**The Immingham Open Cycle Gas Turbine (Amendment)
[(No. 2)] Order 202***

An application has been made, under paragraph 2 of Schedule 6 to the Planning Act 2008(a), to the Secretary of State in accordance with the Infrastructure Planning (Changes to, and Revocation of, Development Consent Orders) Regulations 2011(b) for a non-material change to the Immingham Open Cycle Gas Turbine Order 2020(c).

Amendment to Schedule 12 (design parameters)

3. For the table in Schedule 12, substitute—

Schedule 12 dimension changes highlighted in blue

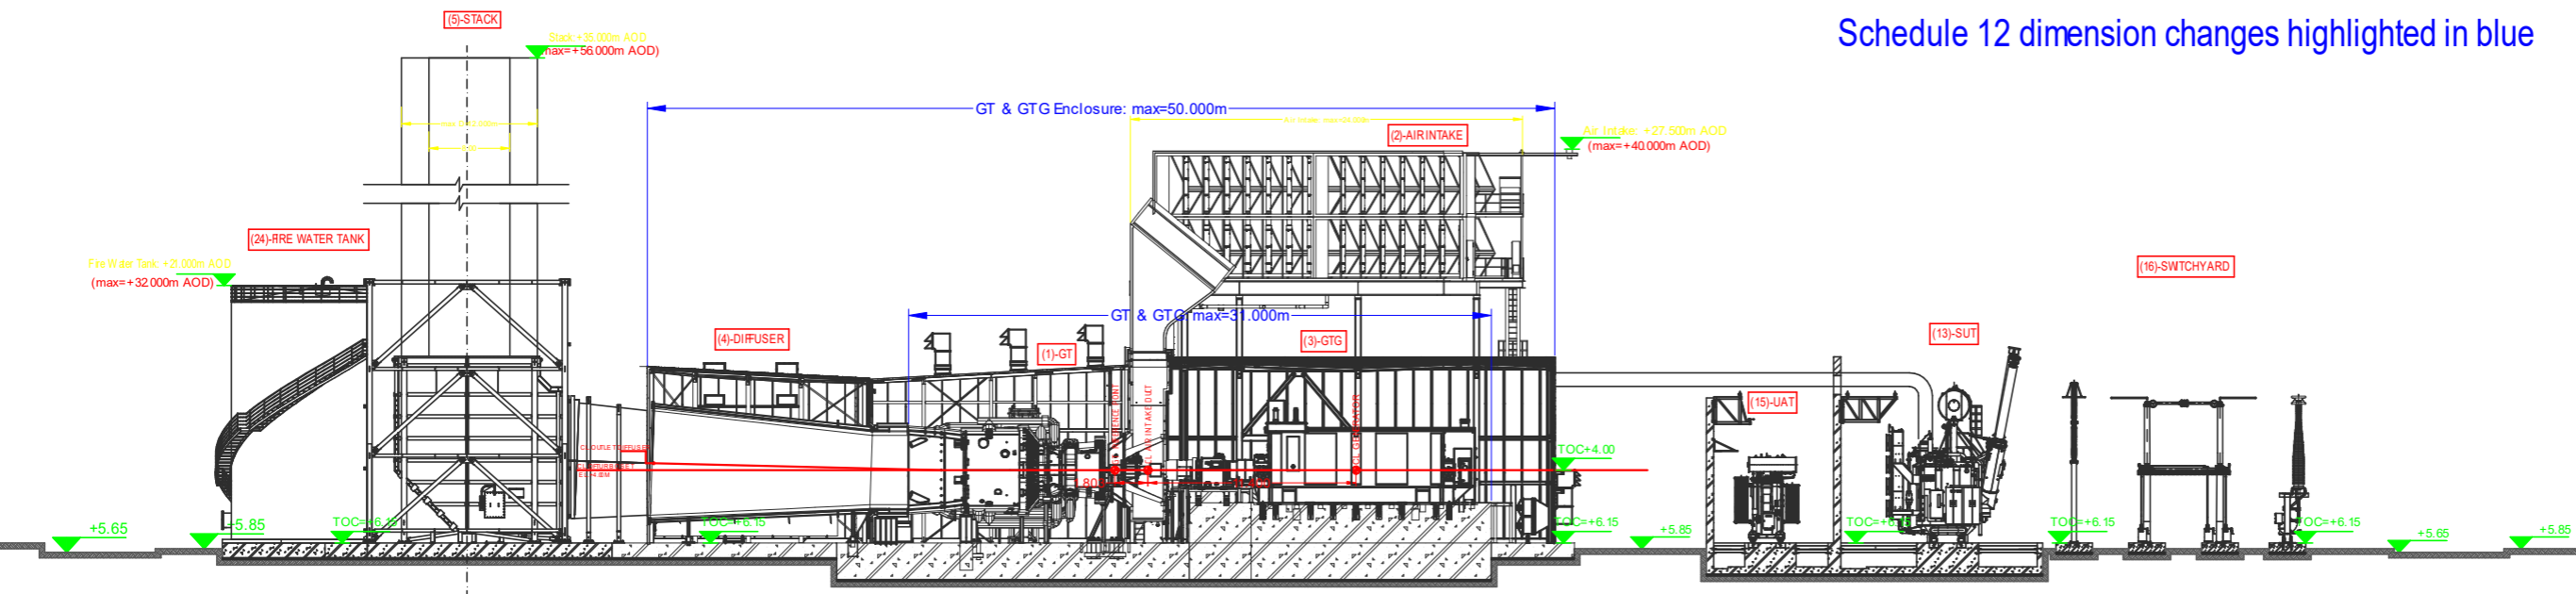
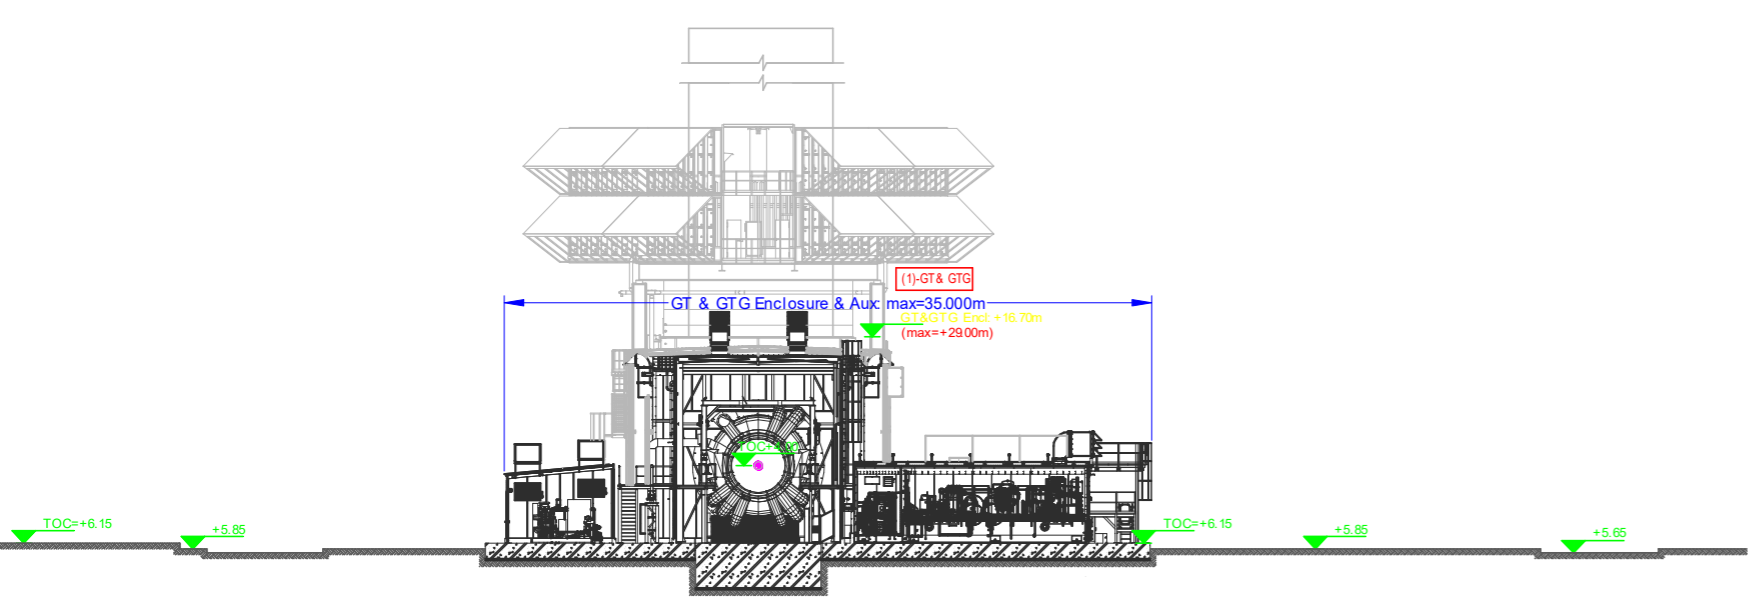
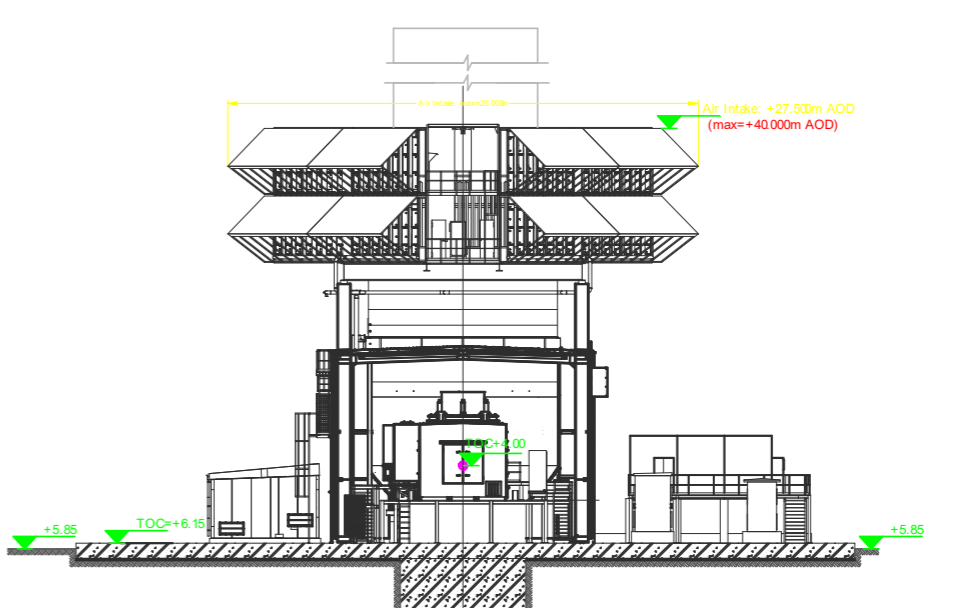
“Table 9

<i>(1) Building or structure</i>	<i>(2) Maximum length (metres)</i>	<i>(3) Maximum width (metres)</i>	<i>(4) Maximum height (metres above 0 meters above ordnance datum)</i>	<i>(5) Maximum diameter (metres)</i>
Single gas turbine and generator	31	20	20	-
Gas turbine building	50	35	29	-
Exhaust stack	-	-	56	12
Air intakes	24	16	40	-
Fin-fan cooler	30	15	17	-
Control room, workshops, stores	35	20	16	-
Demineralised tank, firewater tank	-	-	32	24”
